Helios Renewable Energy Project

Draft Statement of Common Ground with the Environment Agency

Planning Inspectorate Reference: EN010140

November 2024

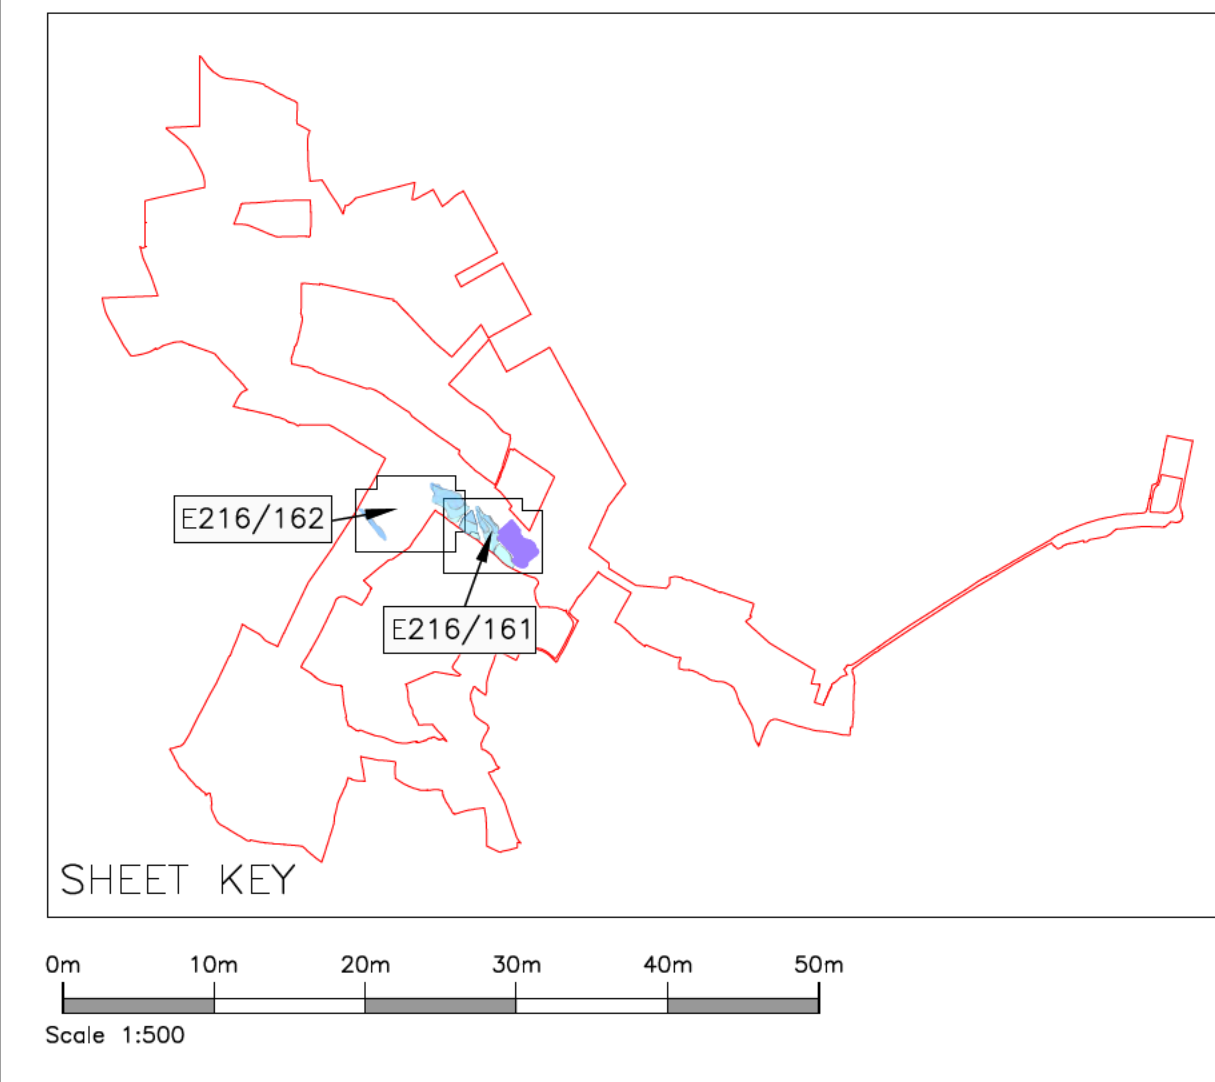
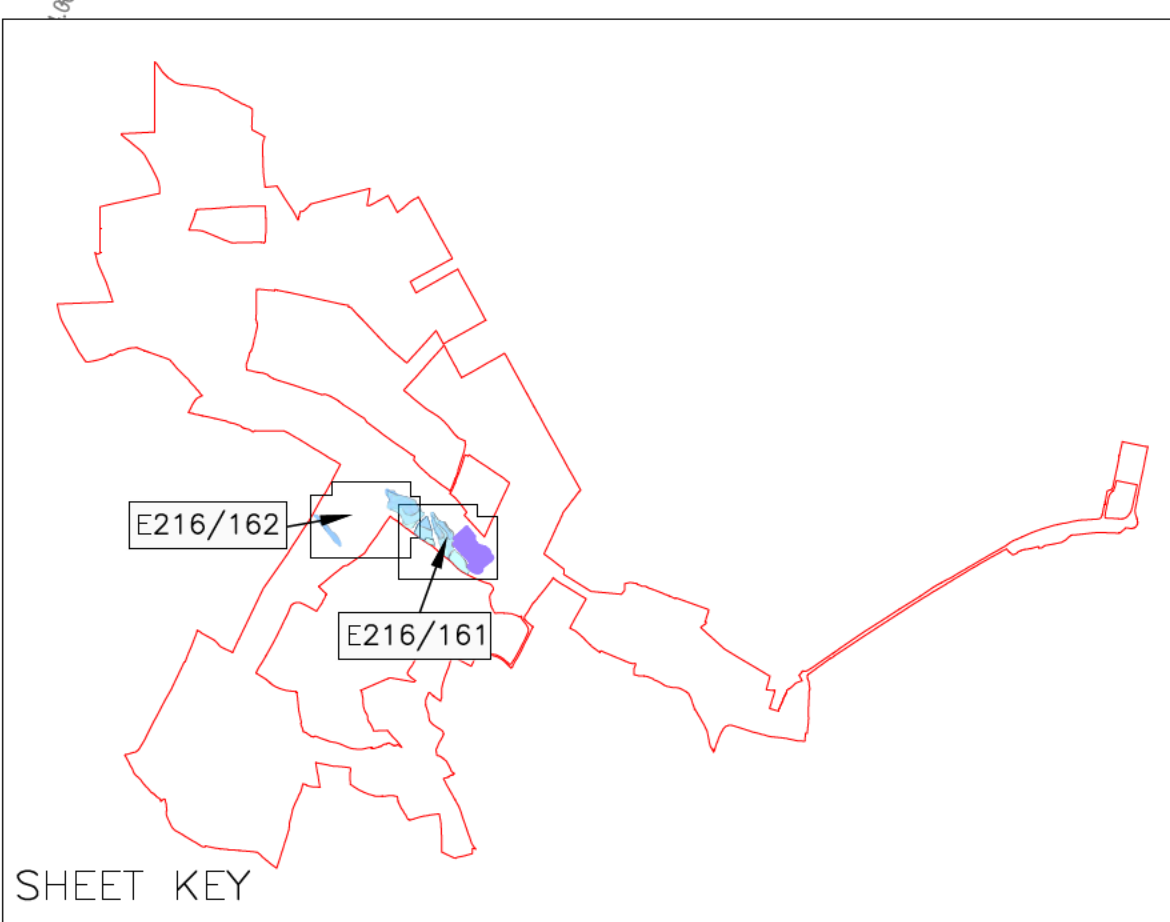
EA-05 [RR-117]	BESS floodplain compensation	<p>4. Remaining risks to the Environment which have not been addressed</p> <ul style="list-style-type: none"> • We require further detail as to how the flood risk compensation scheme as proposed in the Flood Risk Assessment will be secured to ensure this development does not cause flood risk elsewhere. This detail should include phasing of works to ensure that there will be no net loss of floodplain during construction. 	<p>In relation to the flood compensation scheme Paragraph 4.147 of the FRA [APP-232] states:</p> <p>‘The timing to deliver the floodplain compensation scheme for the Substation and BESS Compound taking into account the realisation of the climate change scenarios over the operational lifespan of the Proposed Development would be kept under review as part of a Flood Management Strategy for the Site. The Flood Management Strategy for the Site would be secured by a suitably worded DCO Requirement requiring details to be submitted to and approved by the Local Planning Authority based on the EA approved site-specific flood model.’</p> <p>Paragraph 4.172 of the FRA [APP-232] states:</p>	Under discussion

EA-26 [RR-117]	Flood Risk Assessment	<p><i>Section 4.142-4.147 Appendix 19 Floodplain compensation</i></p> <p><i>Issue - Flood compensation has not been adequately addressed. A floodplain compensation scheme is proposed (as shown in FRA Appendix 19) as mitigation for the loss of floodplain and impeding flow routes. There is no confirmation that this will be taken forward. Part 2 of the Exception Test requires the applicant to demonstrate, via a site-specific flood risk assessment (FRA), that the development will be safe without increasing flood risk elsewhere and, where possible, the development should reduce flood risk overall.</i></p> <p><i>Impact - Failure to confirm steps to reduce flood risk overall</i></p> <p><i>Solution - Amend wording of FRA to commit to the proposed floodplain compensation scheme and include the scheme in Works Plans as part of the DCO.</i></p>	<p>As per response to EA-05</p> <p>Inspection of Drawing No. E216/150 contained in Appendix 11 and Drawing No. E216/153 contained in Appendix 14 of the FRA [APP-234] show that the requirement for floodplain compensation for the Substation and BESS Compound is not required in either the defended Tidal or Fluvial ‘design flood’ and would only be required in the defended Fluvial ‘credible maximum climate change scenario’ (Drawing No. E216/154 Appendix 15 of the FRA [APP-234]. The timing of the delivery of the floodplain compensation scheme is dependent on if the credible maximum climate change scenario comes to pass over the operational lifespan of the development.</p> <p>The Flood Management Strategy for the Site should be secured by a suitably worded DCO Requirement and would contain the mechanism to review the need to implement a floodplain compensation scheme for the Substation and BESS Compound against climate change scenarios over the operational lifespan of the development.</p>	Under discussion

Ref.	Matter	Environment Agency – Current Position	Applicant’s Response	Status
			<p><i>‘The Flood Management Strategy for the Site would keep under review the need to implement a level for level floodplain compensation scheme for the Substation and BESS Compound to mitigate the effect of the earth flood defence bund. A preliminary floodplain compensation scheme within the DCO limits has been shown to be feasible and could be provided on the Site. If required to be implemented, the adaptation measures would ensure that flood risk as a result of the earth flood defence bund would not increase on the Site or elsewhere.’</i></p> <p>This approach is reflected in paragraphs 9.5.16, 9.5.78, and 9.9.8 of the ES Chapter 9 [APP-029].</p> <p>Inspection of Drawing No. E216/150 contained in Appendix 11 and Drawing No. E216/153 contained in Appendix 14 of the FRA [APP-234] show that the requirement for floodplain compensation for the Substation and BESS Compound is not required in either the defended Tidal or Fluvial ‘design flood’ and would only be required in the defended Fluvial ‘credible maximum climate change scenario’ (Drawing No. E216/154 Appendix 15 of the FRA [APP-234]). The timing of the delivery of the floodplain compensation scheme is dependent on if the credible maximum climate change scenario comes to pass over the operational lifespan of the development.</p> <p>The Flood Management Strategy for the Site should be secured by a suitably worded DCO Requirement and would contain the mechanism to review the need to implement a floodplain compensation scheme for the Substation and BESS Compound against climate change scenarios over the operational lifespan of the development.</p> <p>The wording of the DCO Requirement could include the need for a CEMP to be agreed covering the construction of the floodplain compensation scheme and could include details of the phasing of the construction.</p> <p>The wording of the DCO Requirement will be agreed with the EA.</p>
